ENG-PUDSP20007-R5-PUDSP.pdf Markup Summary

MIDTOWN COLLECTION AT HANNAH RIDGE			
FILING NO. 3			
PUD DEVELOPMENT PLAN			
PRELIMINARY PLAN			
DESIGNED BY	KC	SCALE	DATE
DRAWN BY	KC	(H) 1"= 40'	SHEET 2 OF 10
CHECKED BY	KRC	(V) 1"= N/A	JOB NO. 1116.35

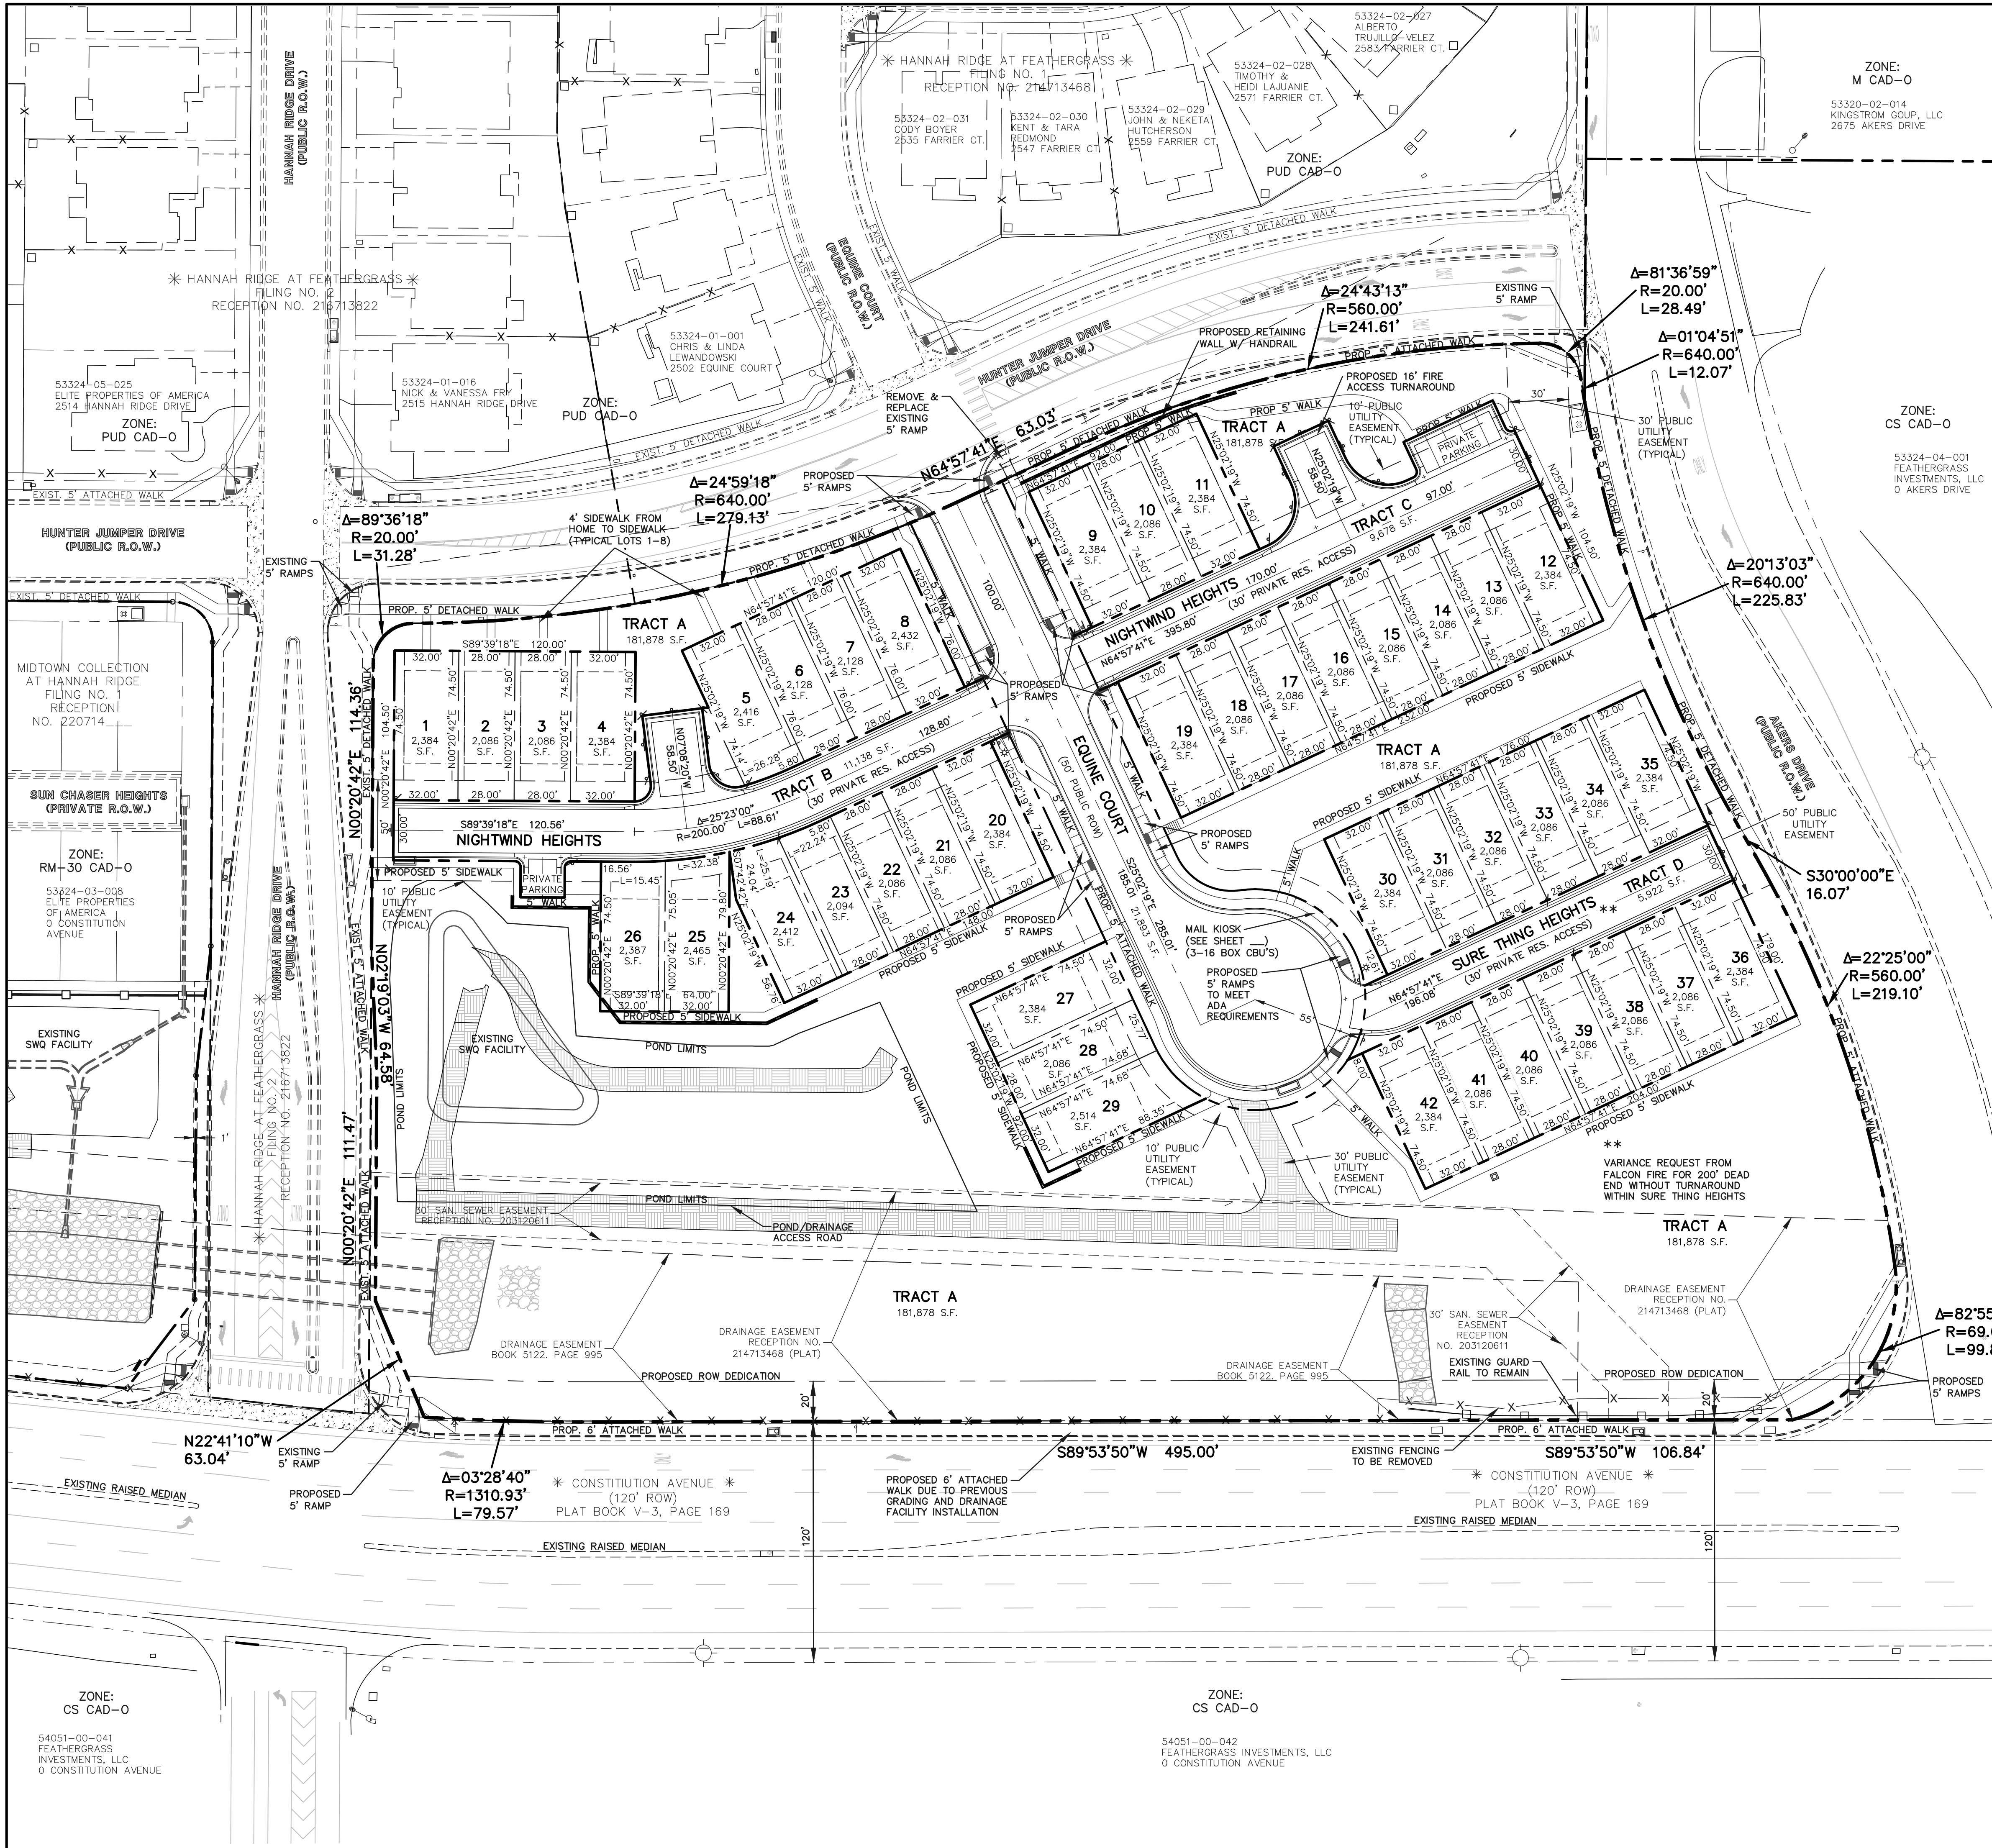
Label approximate street grades on all proposed roads

Is there sidewalk here?
